DECISION DELEGATED TO HEAD OF PLANNING

Application No: H13-1081-22 **Applicant:** Mr J Hitcham
Proposal: Residential Development
Location: Rear Of 18 Roman Bank Moulton Seas End Spalding
Terminal Date: 3rd January 2023

Project	RESIDENTIAL DEVELOPMENT EAST OF I-18 & 200 BOWMAN PARK, MOLITION 35.45 BLD. SPALDING, LINC 5, FBI 2 BLD.		
Client	J. HITCHAM.		
Drawing	SITE & LOCATION PLANS.		
Job Ref.	4087-22.	Drawing No.	01.
Date	OCTOBER 2022.	Drawn	S.L.D.

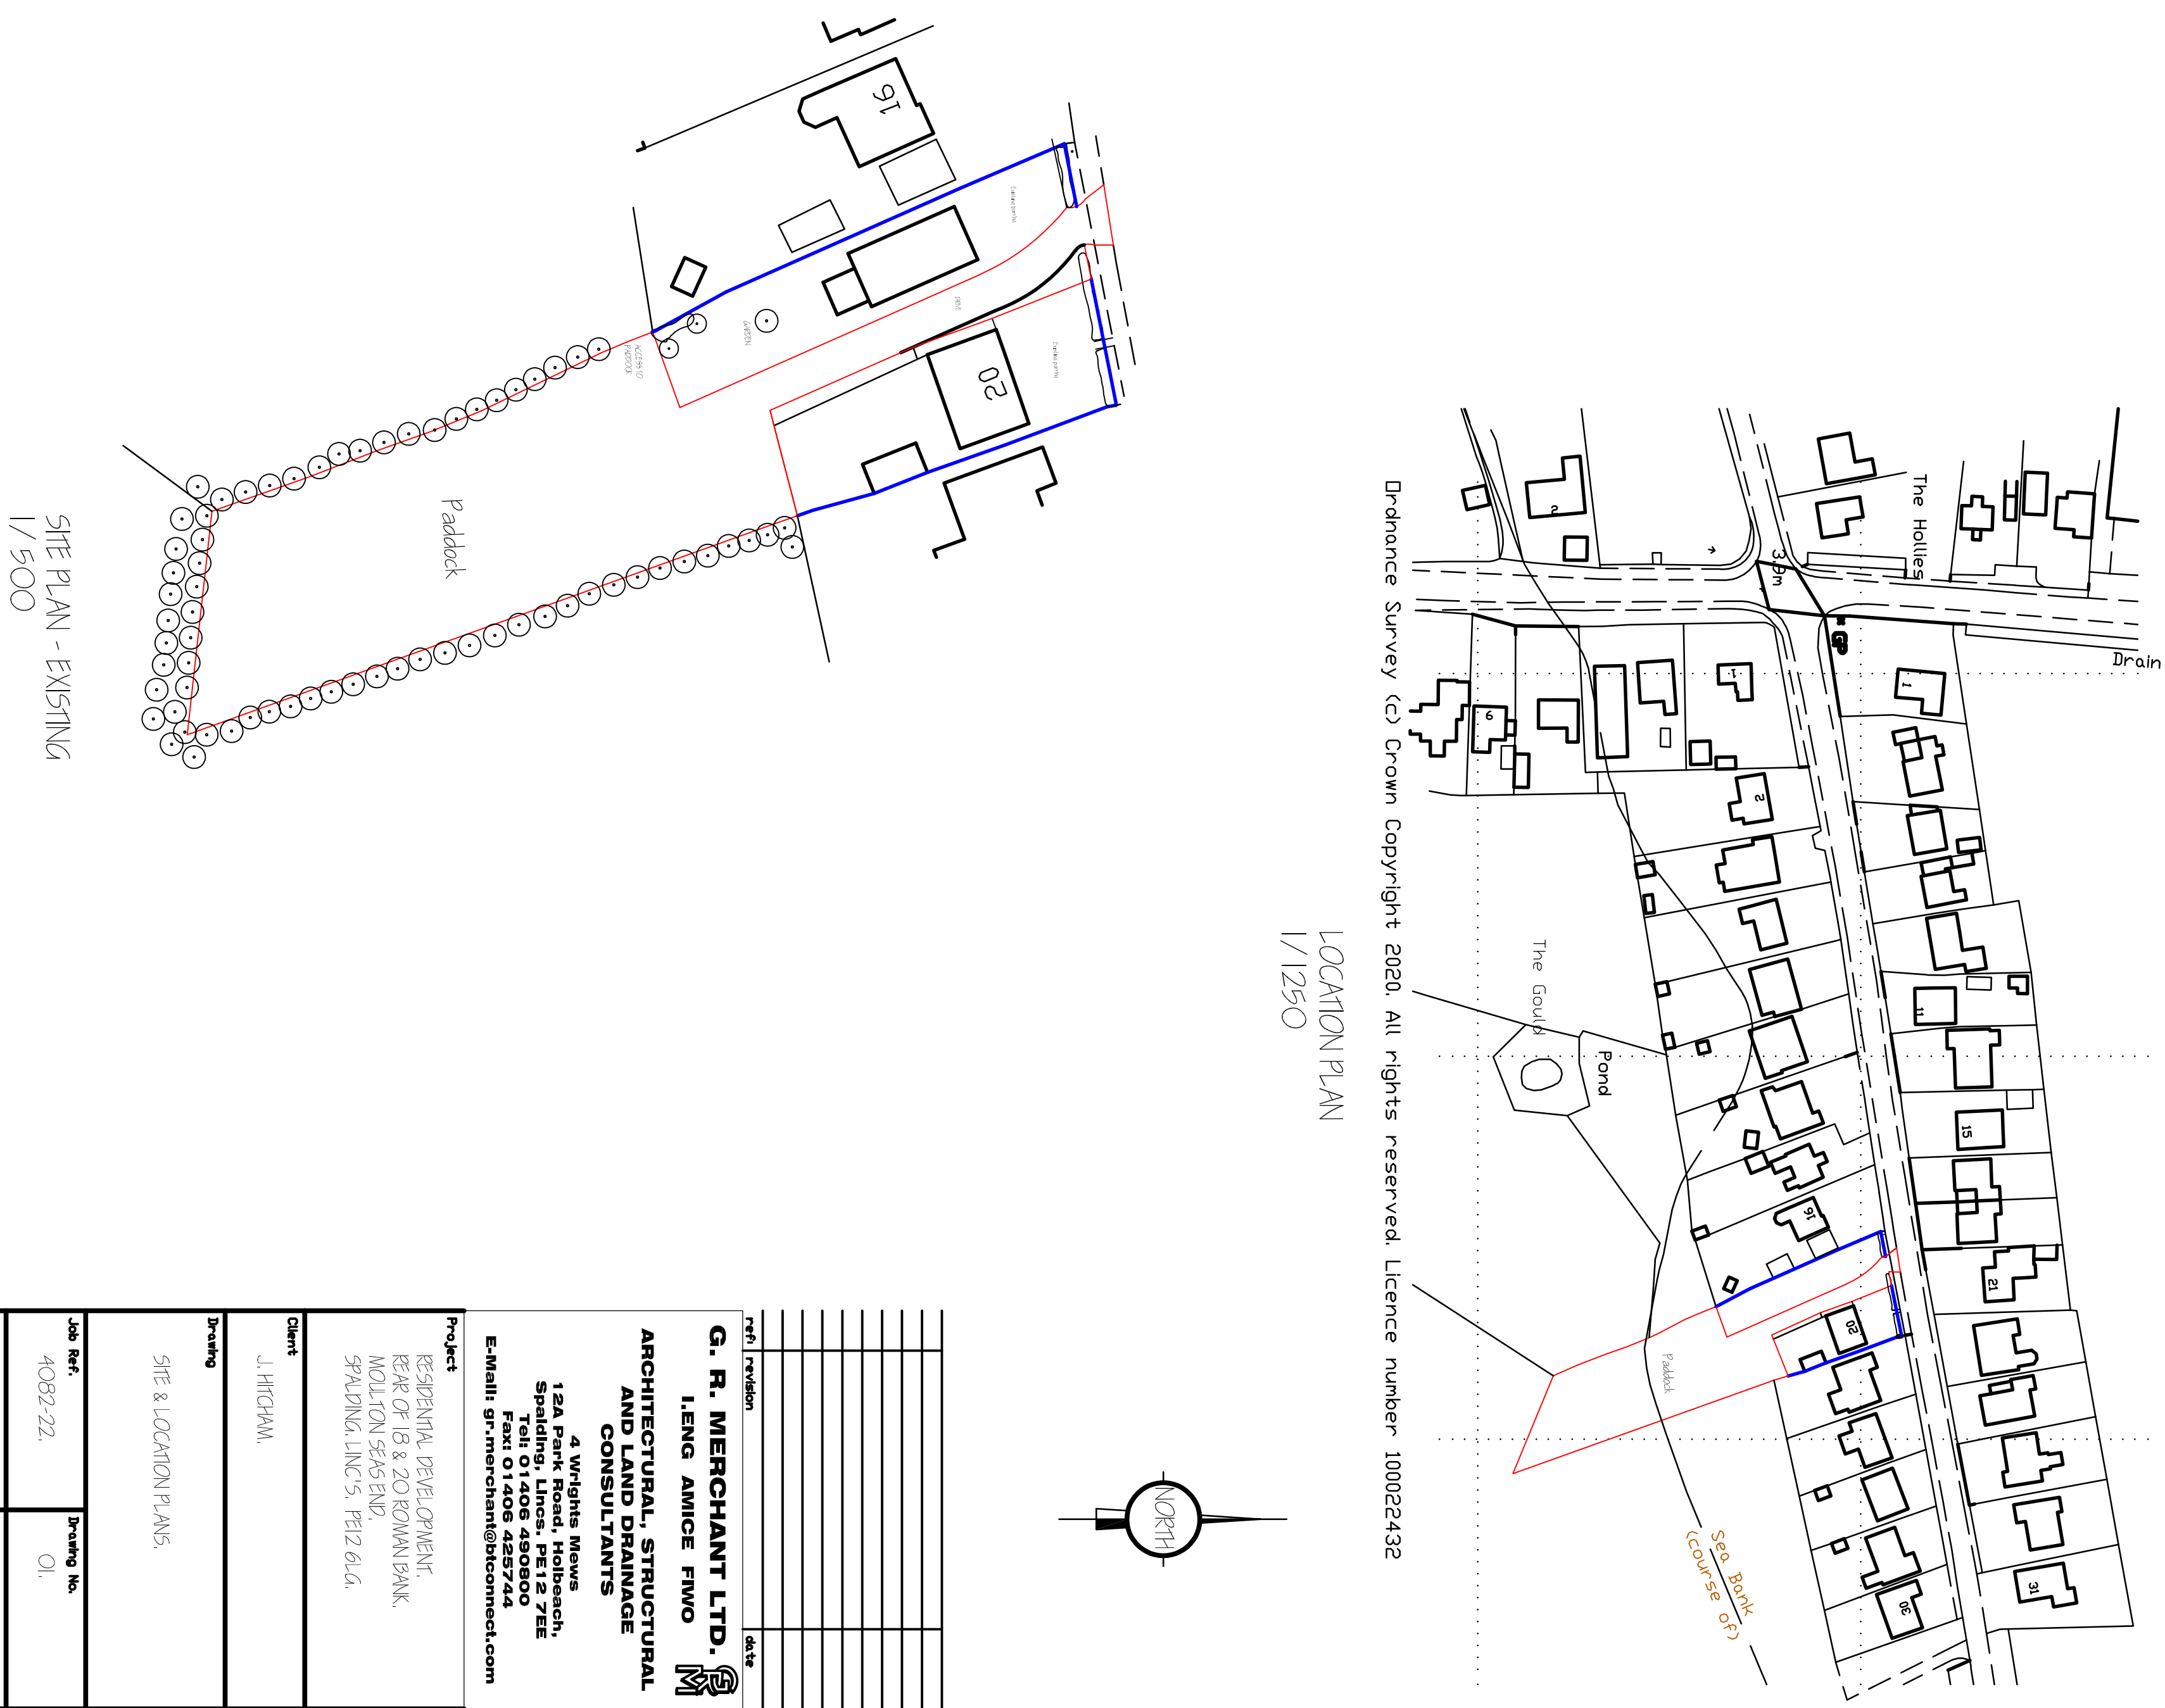
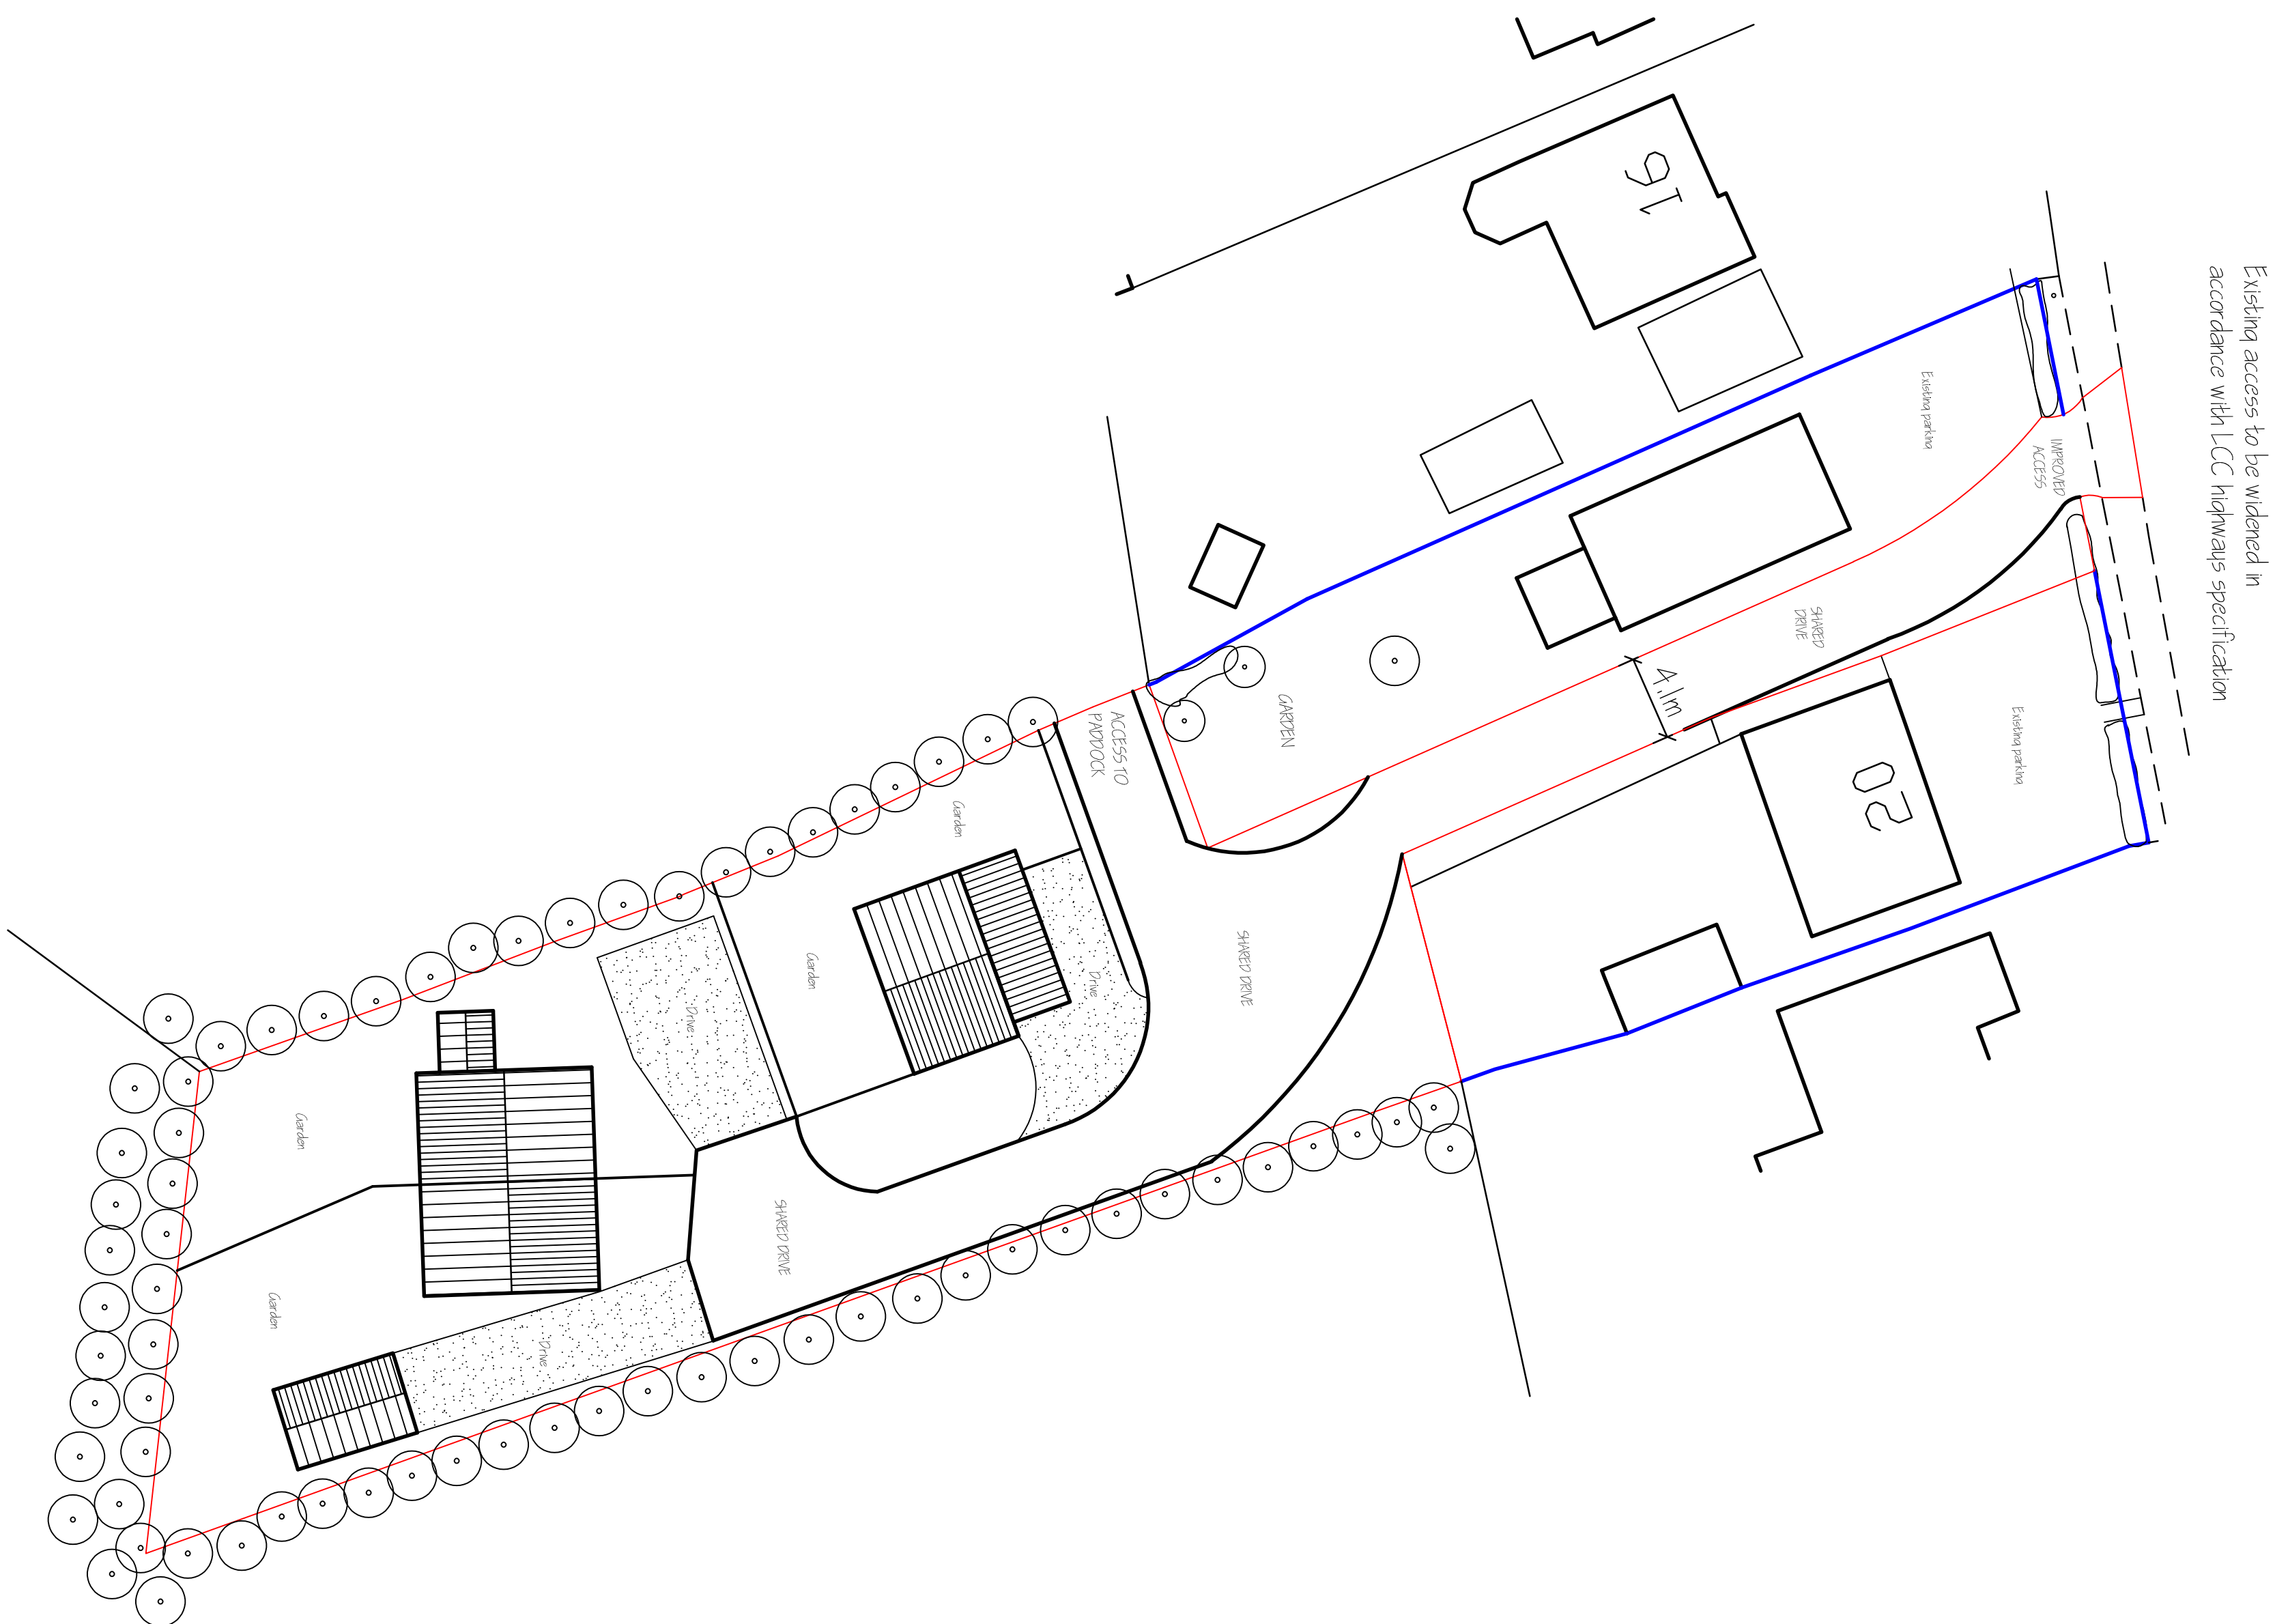
The proposal has been submitted with all matters reserved for later approval; however, an indicative proposed layout has been submitted illustrating that the potential form of development, comprising a detached dwelling and two semi-detached dwellings to the rear of 18 Roman Bank, Moulton Seas End.

The application site would be accessed between two existing detached dwellings, which are within the settlement boundary defined on the Local Plan proposals map for Moulton Seas End. However, the large extent of the application site, as illustrated within the red outlined location plan and the indicative siting of the proposed dwellings, lies within the open countryside as defined on the Local Plan proposals map.

The Fire Authority objects to this planning application on the grounds of inadequate access and turning for a fire appliance. This is the opinion of the Fire Authority as a specific requirement under the Building Regulations.

Access to buildings for fire appliances and fire fighters are specified in the Building Regulations 2010 Part B5. The vehicle access road will be a minimum width between kerbs for pumps of 3.7m. The minimum turning circle between kerbs for pumps should be 16.8m and between walls 19.2m. A turning facility is required because the dead-end access route is over 20m long. This can be a hammerhead or a turning circle.

With regards to layout and design, the proposed dwellings would not be in keeping with the pattern of the residential frontage along the southern side of Roman Bank. The proposal would not be integrated sensitively with the character and appearance of the surrounding area.

Residential properties are located to the north of the main body of the site. However, the indicative plan shows satisfactory separation distances between the existing properties and the proposed new development generally. It is considered that the site could be developed without materially harming the amenity of nearby residents in terms of overlooking, lack of privacy, overbearing effect, overshadowing, noise, and disturbance, etc.
